PORTISHEAD BRANCH LINE – METROWEST PHASE 1

**Schedule of ExA's recommended amendments to the Applicant's draft DCO
submitted at Deadline (D)6 [REP6-008]**

2.57 - Portbury Hundred Location of Additional Tree Planting

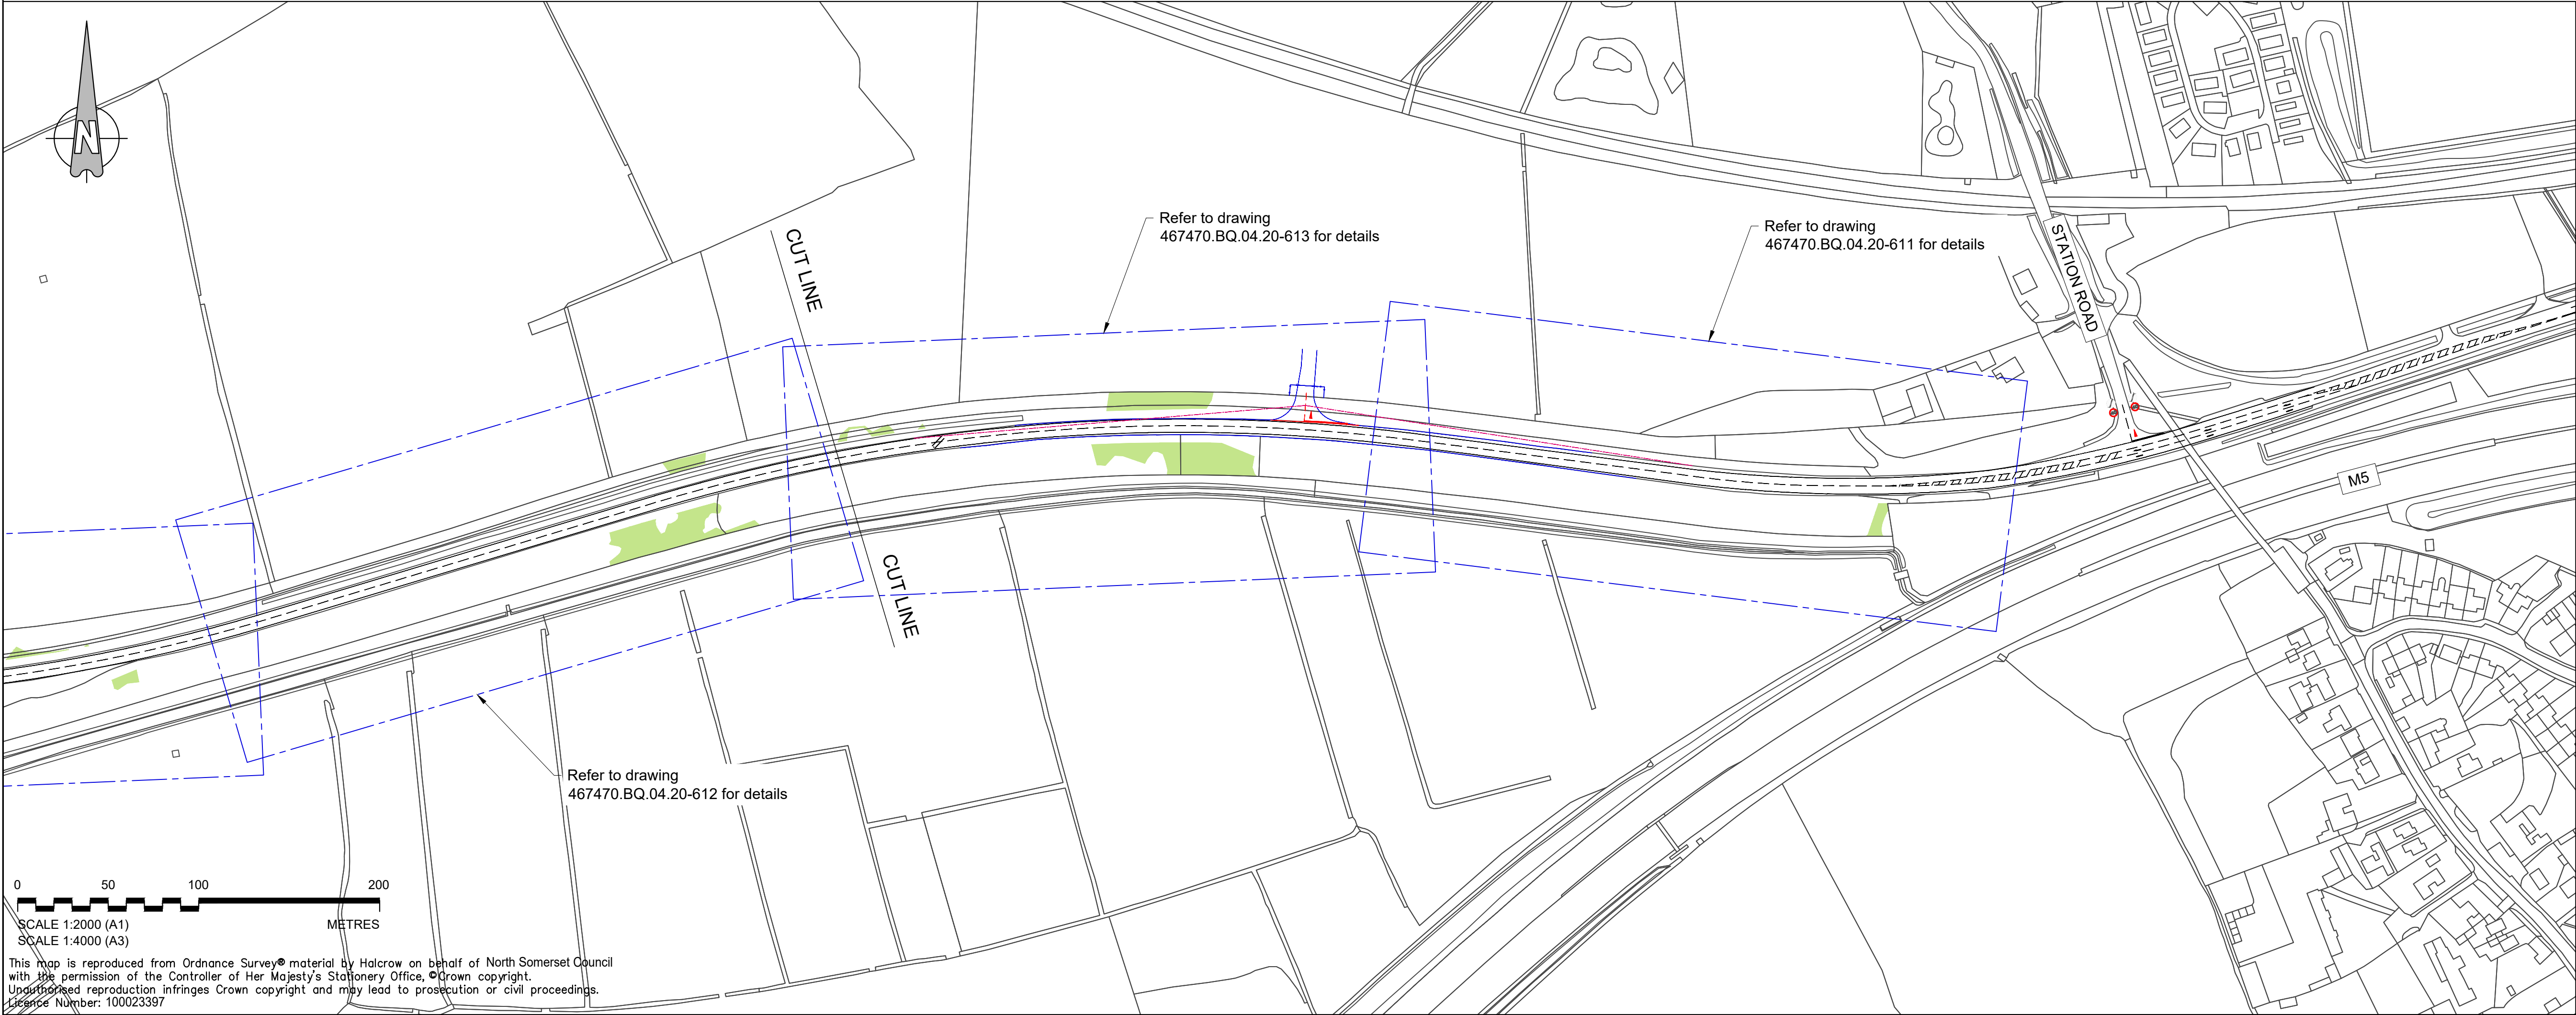
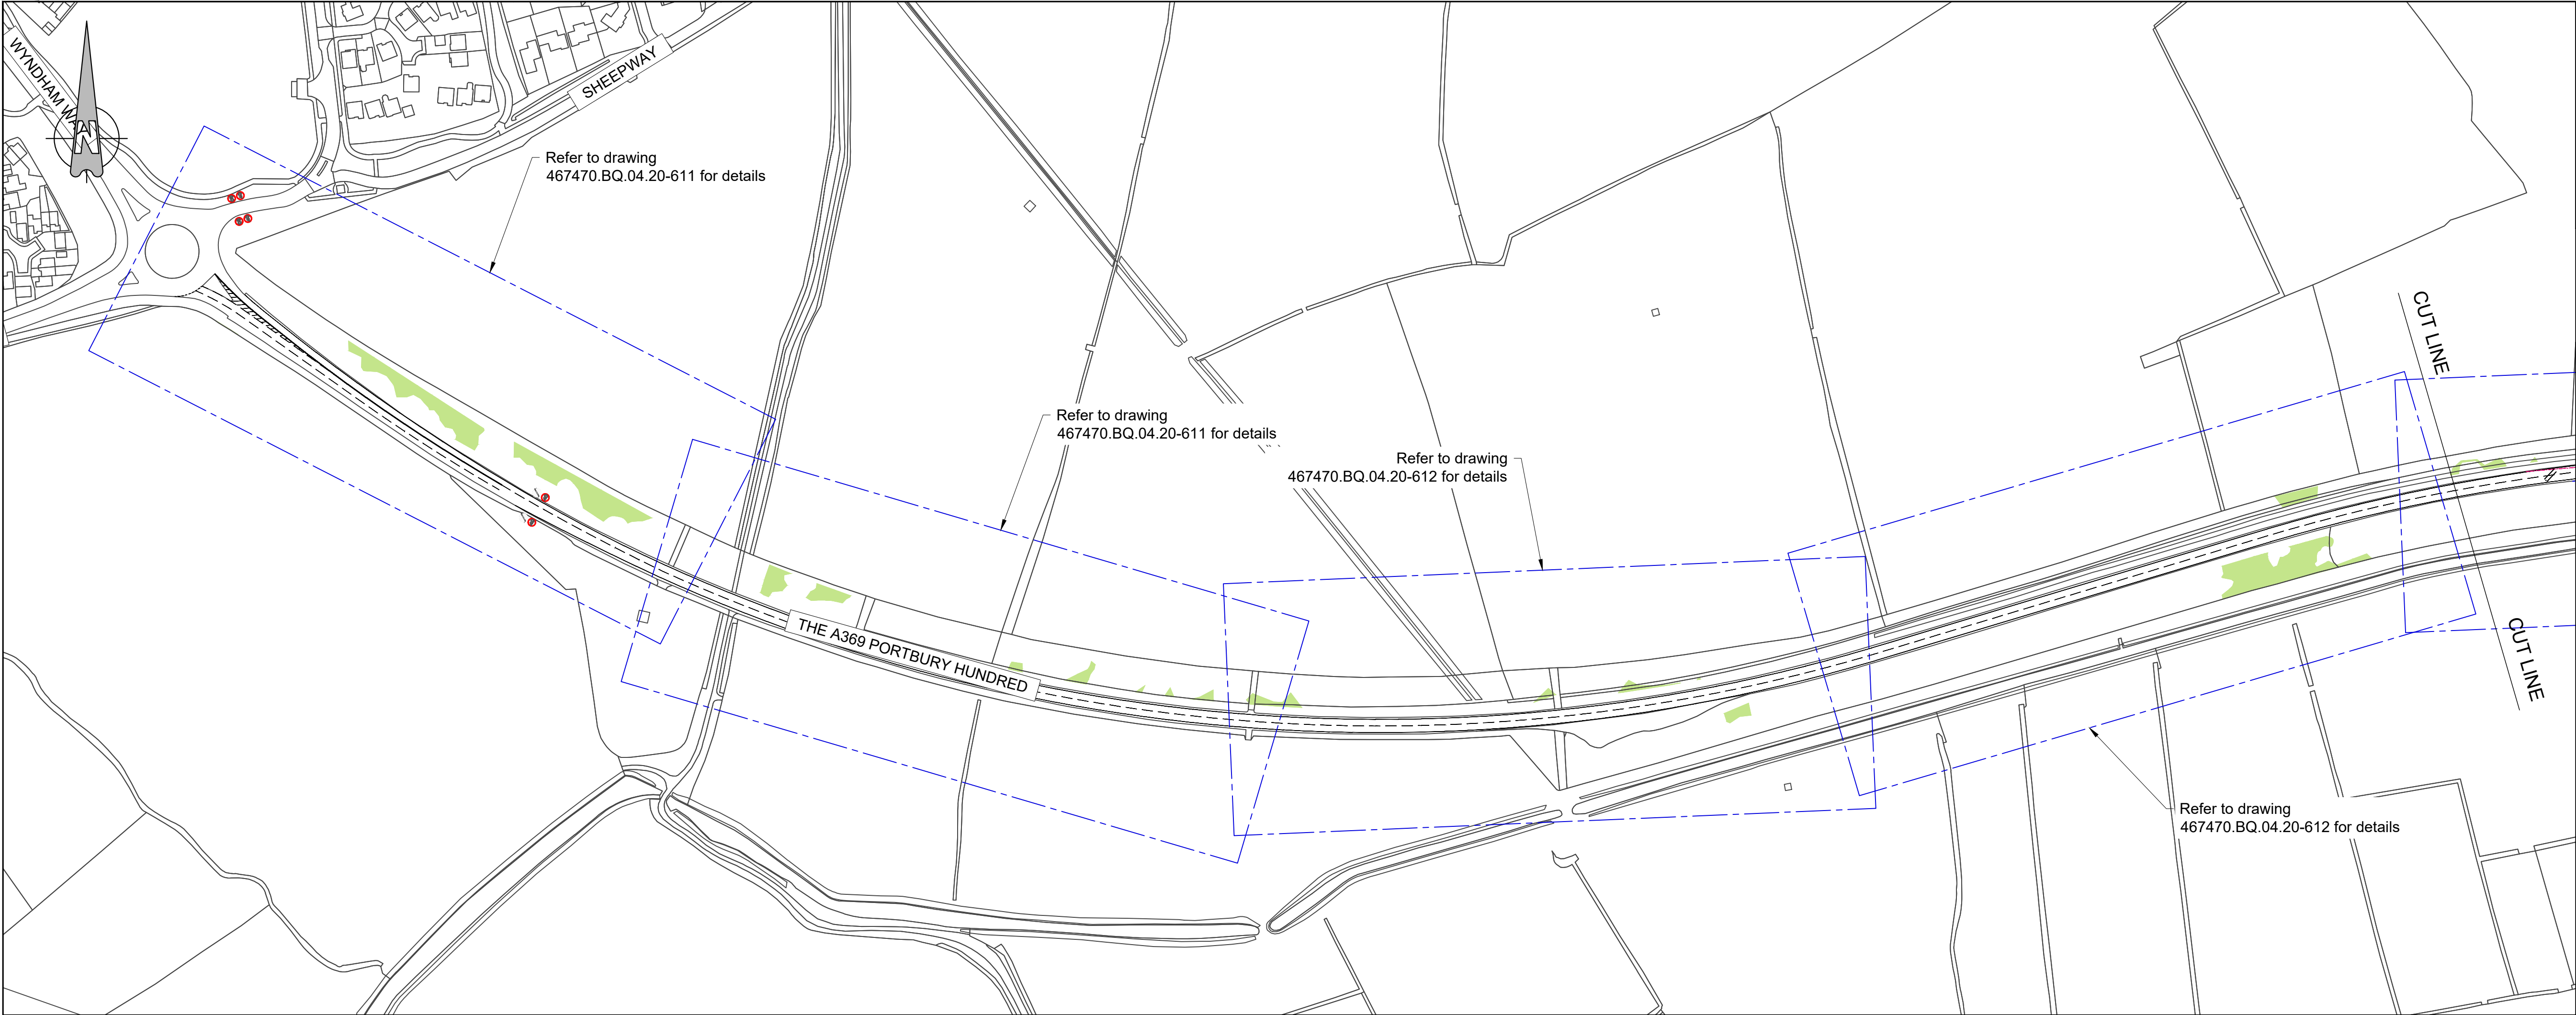
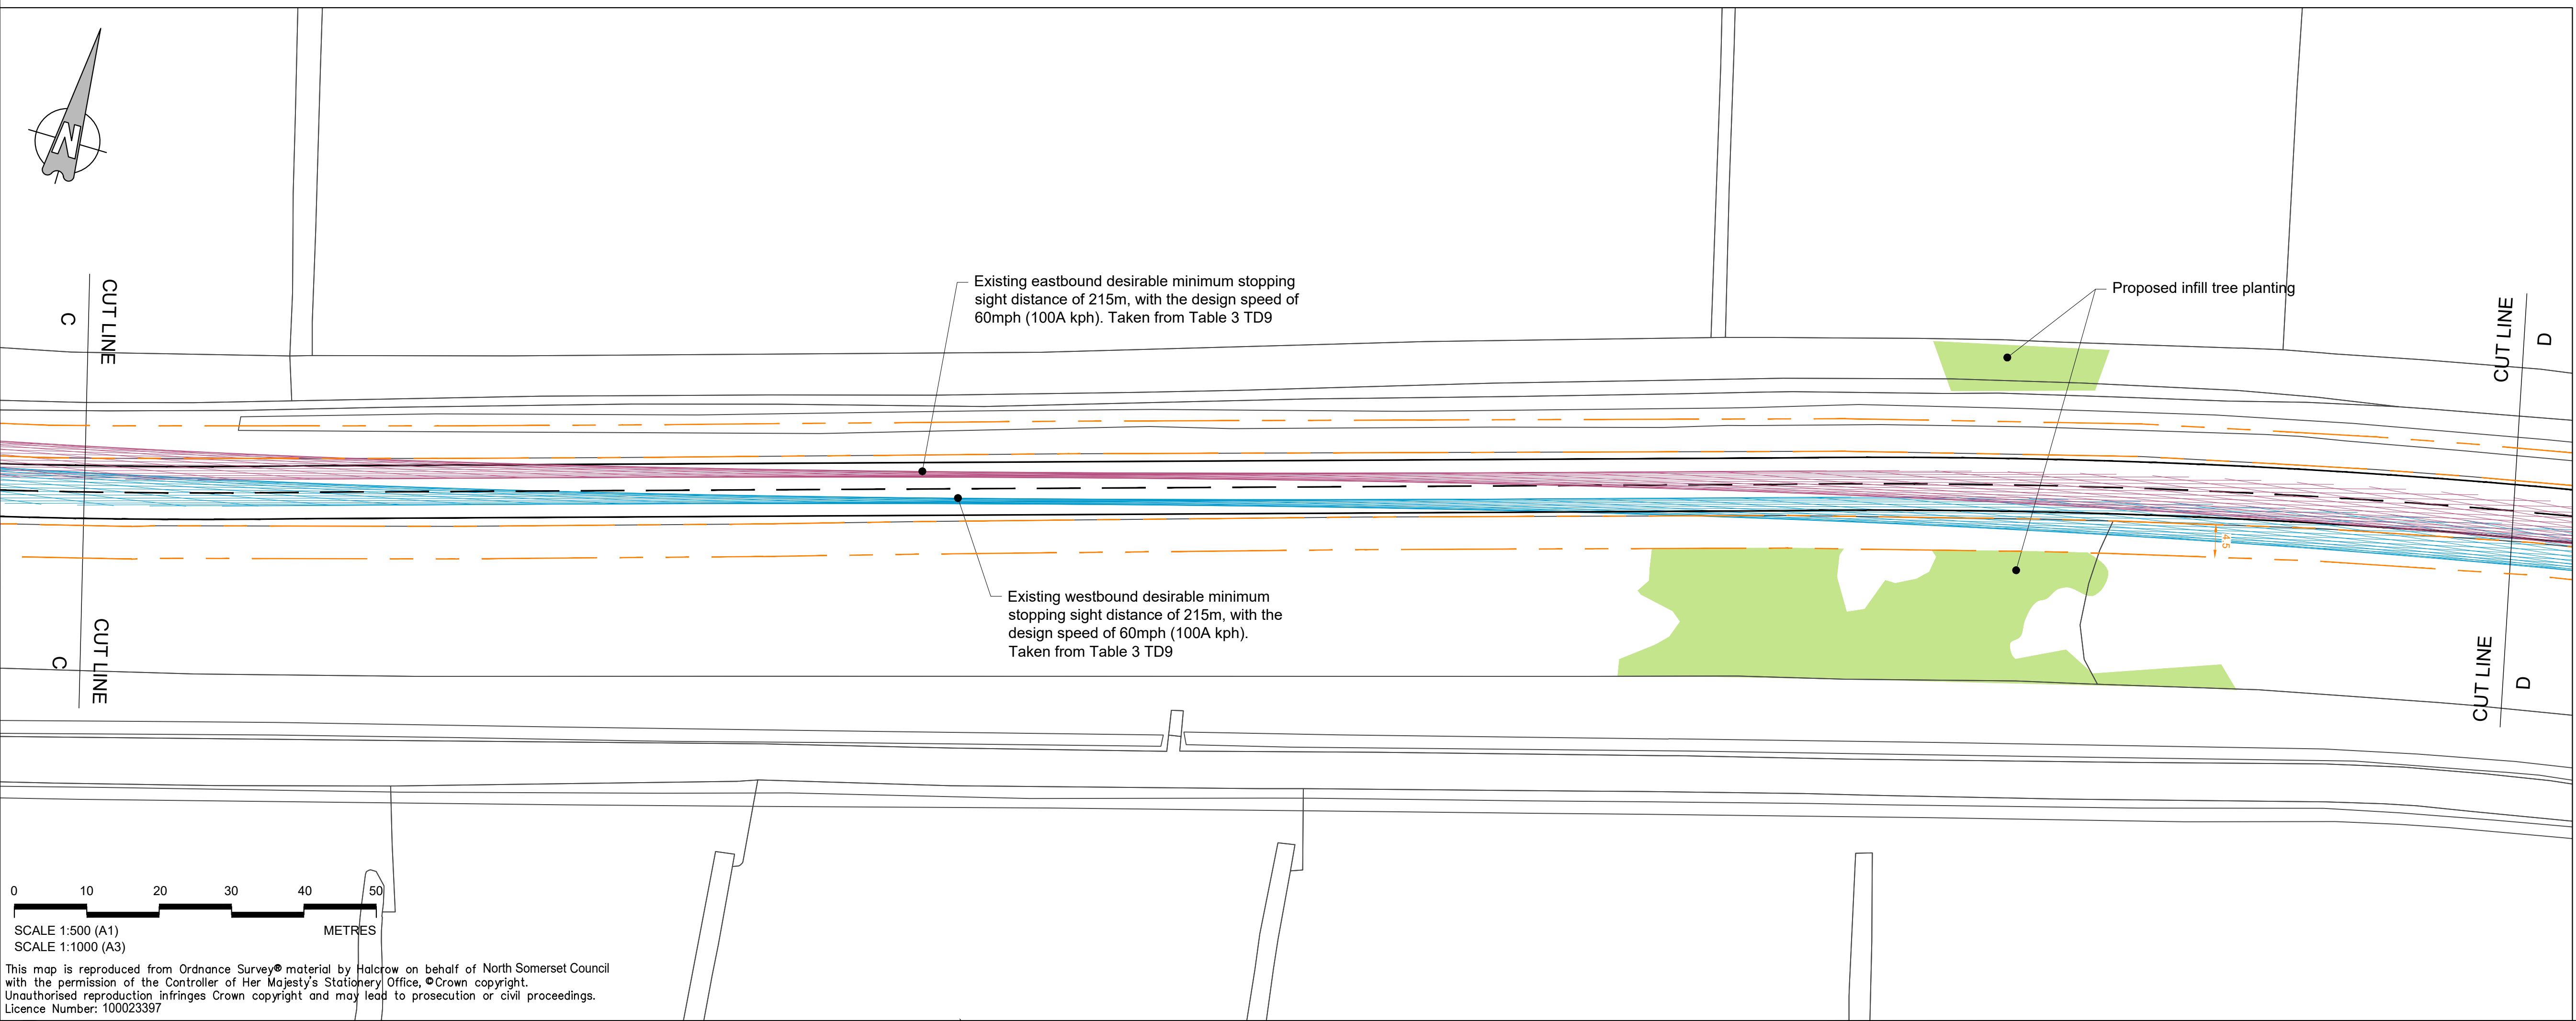
<p>Schedule 2 Requirement 24 <i>For the protection of bats</i></p>	<p>24(1) Work Nos 1, 1A, 1B and 1C must not commence until written details of the proposed tree planting on the A369 Portbury Hundred classified road must have been approved in writing by the relevant planning authority</p>	<p>24(1) Work Nos 1, 1A, 1B and 1C must not commence until written details of the proposed tree planting on the A369 Portbury Hundred classified road must have been approved in writing by the relevant planning authority in consultation with the relevant</p>	<p>As the tree planting is proposed to provide additional foraging for commuting bats the ExA consider that it would be appropriate that Natural England should be consulted on the details</p>

in consultation with the relevant highway authority. The details submitted for approval must accord with the Portbury Hundred location of additional tree planting plans.	highway authority and Natural England . The details submitted for approval must accord with the Portbury Hundred location of additional tree planting plans.	
Schedule 2 Requirement 25 <i>Permanent fencing outside of Avon Gorge Woodlands SAC</i>	25(1) subject to paragraphs (2) and (3) and without affecting requirement 31(4) a stage of the works must not commence until written details of any permanent security fencing to be installed in connection with the that stage, together with a timetable for its installation, have been submitted to and approved by the relevant planning authority. (2) Where new fencing is to be provided that does not fall within a stage, and is outside of the Avon Gorge Woodlands SAC any permanent security fencing	25(1) subject to paragraphs (2) and (3) and without affecting requirement 31(4) a stage of the works must not commence until written details of any permanent security fencing to be installed in connection with that stage, together with a timetable for its installation, have been submitted to and approved by the relevant planning authority. (2) Where new fencing is to be provided that does not fall within a stage, and is outside of the Avon Gorge Woodlands SAC any permanent security fencing to be installed must be of a nature substantially in accordance with the details set	The insertion of this wording would give the Applicant the flexibility to change the fencing if required for operational safety reasons but would mean that Requirement 35 (2) would apply so that it would ensure that in this location any variations to the fencing would not give rise to any materially new or materially different environmental effects from those assessed in the ES
